<b>Project name</b>	The 'Net Zero Teesside Project'
<b>File reference</b>	EN010103
<b>Status</b>	<b>Final</b>
<b>Author</b>	The Planning Inspectorate
<b>Date</b>	21 June 2021
<b>Meeting with</b>	Net Zero Teesside Power Limited and Net Zero North Seas Storage Limited
<b>Venue</b>	Microsoft Teams
<b>Meeting objectives</b>	Project Update
<b>Circulation</b>	All attendees

### Summary of key points discussed and advice given

The Inspectorate outlined the headline issues which were leading to a decision of non-acceptance:

TITLE
WORKS PLAN, DOCUMENT REF. 4.4
WORK NUMBER 2 - GAS CONNECTION WORKS
REFERENCE
NET_JAN25_DCO_4.4_v7
SHEET NUMBER
7 of 26
DATE
JANUARY 2025

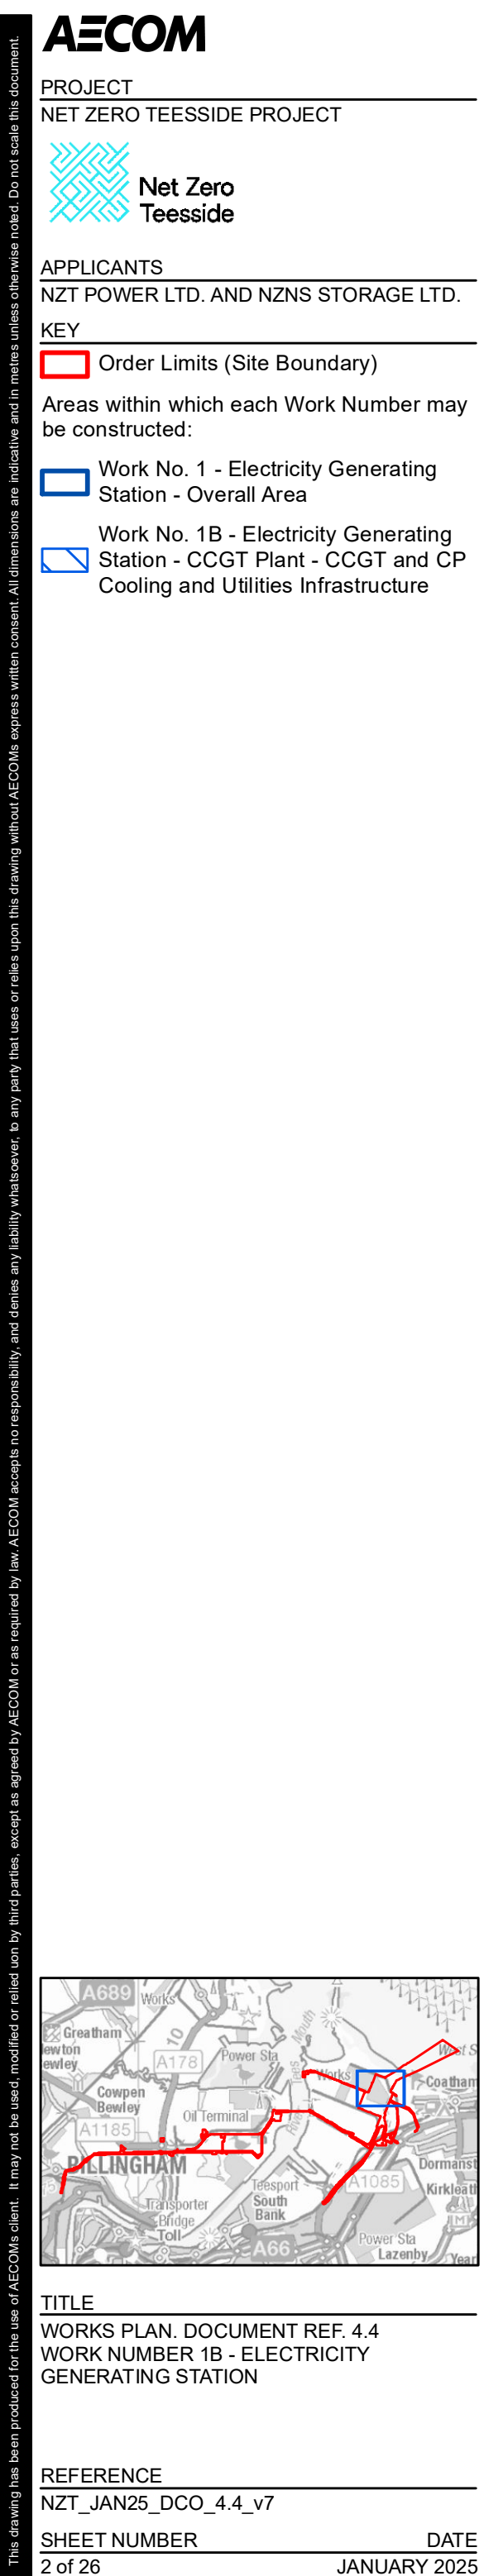
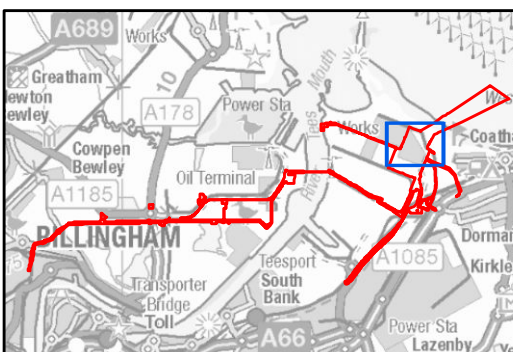
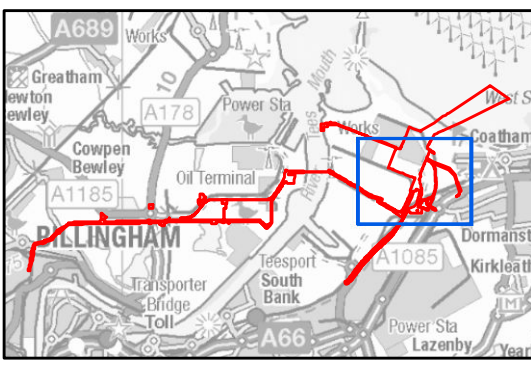
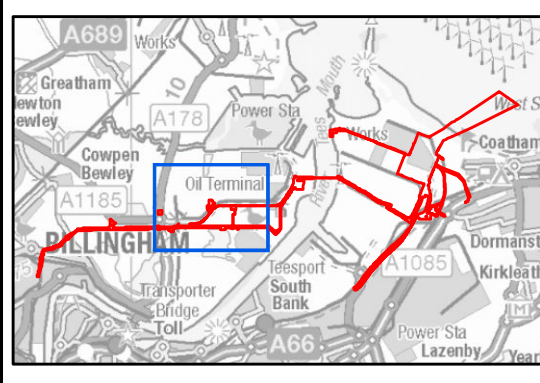
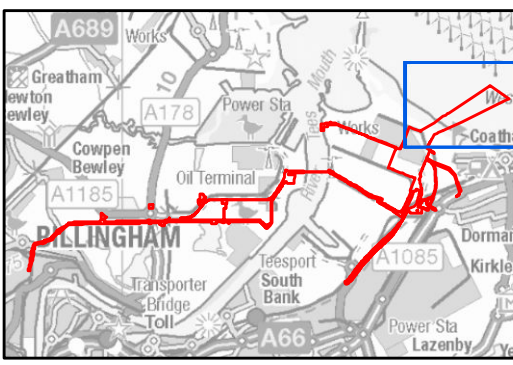
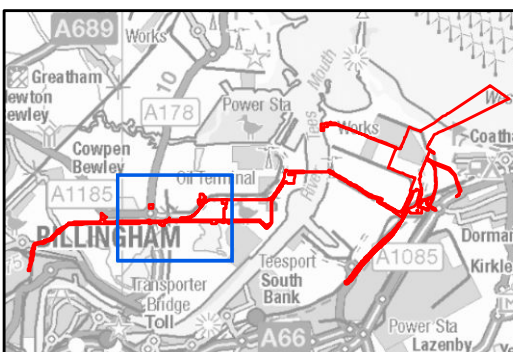
- The Works plans were difficult to decipher as differentiation between above ground and below ground hatching was unclear. The Inspectorate advised the Applicants to use graphic shading techniques that enable clear differentiation of each Works No.

<p>The Works plans were difficult to decipher as differentiation between above ground and below ground hatching was unclear. The Inspectorate advised the Applicants to use graphic shading techniques that enable clear differentiation of each Works No.</p>	<p>The Works Plans have been amended to provide greater clarity in respect of the differentiation between the different works.</p>	<p>Works Plans (Document Ref. 4.4).</p>
<p>The Inspectorate commented that Figure 3-2 of the ES usefully clarifies the relationship between different “development areas”. To assist</p>	<p>Figure 3-2 Development Areas has been refined to show the location of the alternative development option routes for the Natural Gas Connection</p>	<p>Works Plans (Document Ref. 4.4)</p>
